Memo

To: Jennifer Murray, Windmill Development Corporation
From: Carl Bray, Bray Heritage
Date: Friday, September 8, 2017
RE: 15 Aylmer Avenue/Southminster United Church CHIS/Response to Agency Comments

**SITE SECTION THROUGH CHURCH**  
 1:400  
 May 19, 2017

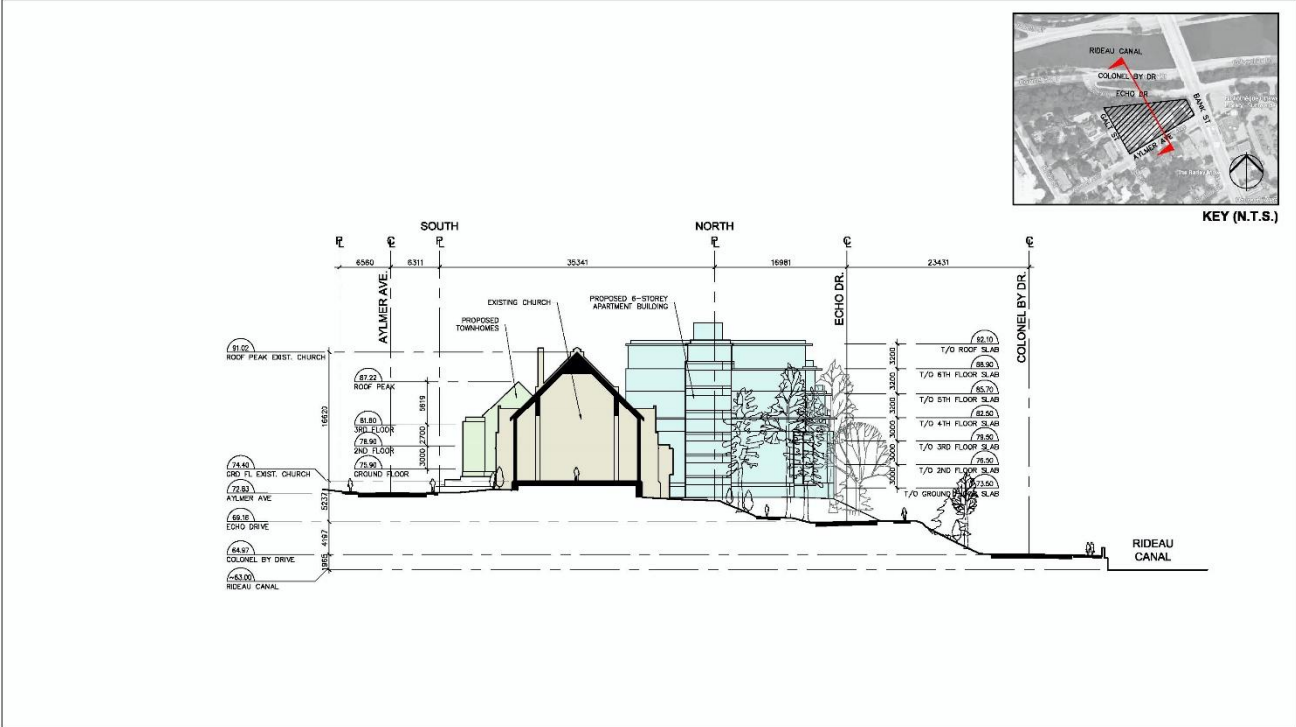
- In the letter of 18 July, 2017, Parks Canada staff requested views of the proposed development from the Canal, specifically asking for renderings of the north façade of the proposed six storey building. Staff also had concerns about the amount of glazing proposed for the building, suggesting that masonry would be more compatible with the existing church.
- In an email of 6 July, 2017, National Capital Commission staff also requested renderings of the north façade and provided mapping showing suggested view locations. Staff also recommended material changes (masonry substituting for glazing, especially in terms of impact on night views of the building), and requested further information on measures for conserving mature trees on NCC lands abutting the development site.

The renderings shown here have been prepared by the project architect, using photographs supplied by the NCC. Each provides an approximation of the view of the church from two key viewpoints along the Canal: from the east, looking towards the bridge and the church façade; and to the south, from the opposite bank of the Canal (this also approximates the view from the Canal navigation channel). In both renderings, the proposed six storey residential building is visible next to the church and slightly above the treetops. The scale relationship is also shown in the two sectional views provided above. The new building is slightly higher than the church but does not extend beyond the rear half of the church. As a result, the church façade and the majority of its massing are clearly evident, especially when viewed from Bank Street, from the bridge, and from the Canal looking west towards the bridge. Views directly south from the Canal have the new building overlapping the rear portion of the church.

In terms of visual impact, the character of views from the Canal of the subject property has not been specified in either Parks Canada or National Capital Commission policies and guidelines. At present, existing views of the church as seen from the Canal have it appearing behind and above a screen of mature trees. In order to reduce the visual impact of the proposed six storey building to be located on the north side of the church, between it and the Canal, both agencies have suggested further mitigation measures that involve height reduction and material changes. Lowering the height of the proposed residential building, while somewhat reducing its visibility from the Canal, would jeopardize the feasibility of the church rehabilitation project and thus has to be weighed against the potential cancellation of a development that has significant community benefits. More applicable mitigation measures here could involve material changes for the building exterior, currently shown as being extensively glazed. By increasing the amount of masonry cladding on the building such that the ratio of wall to window is greater, and the overall colour is darker, the new building will be able to blend more easily with the tree canopy and with the stone exterior of the church. Conserving the mature trees on NCC property will retain the existing tree screen.

- Increasing the amount of masonry cladding on the exterior of the proposed six storey building
- As part of the final submission, providing revised renderings showing these changes
- Working with the NCC to conserve the mature trees that are adjacent to the development site
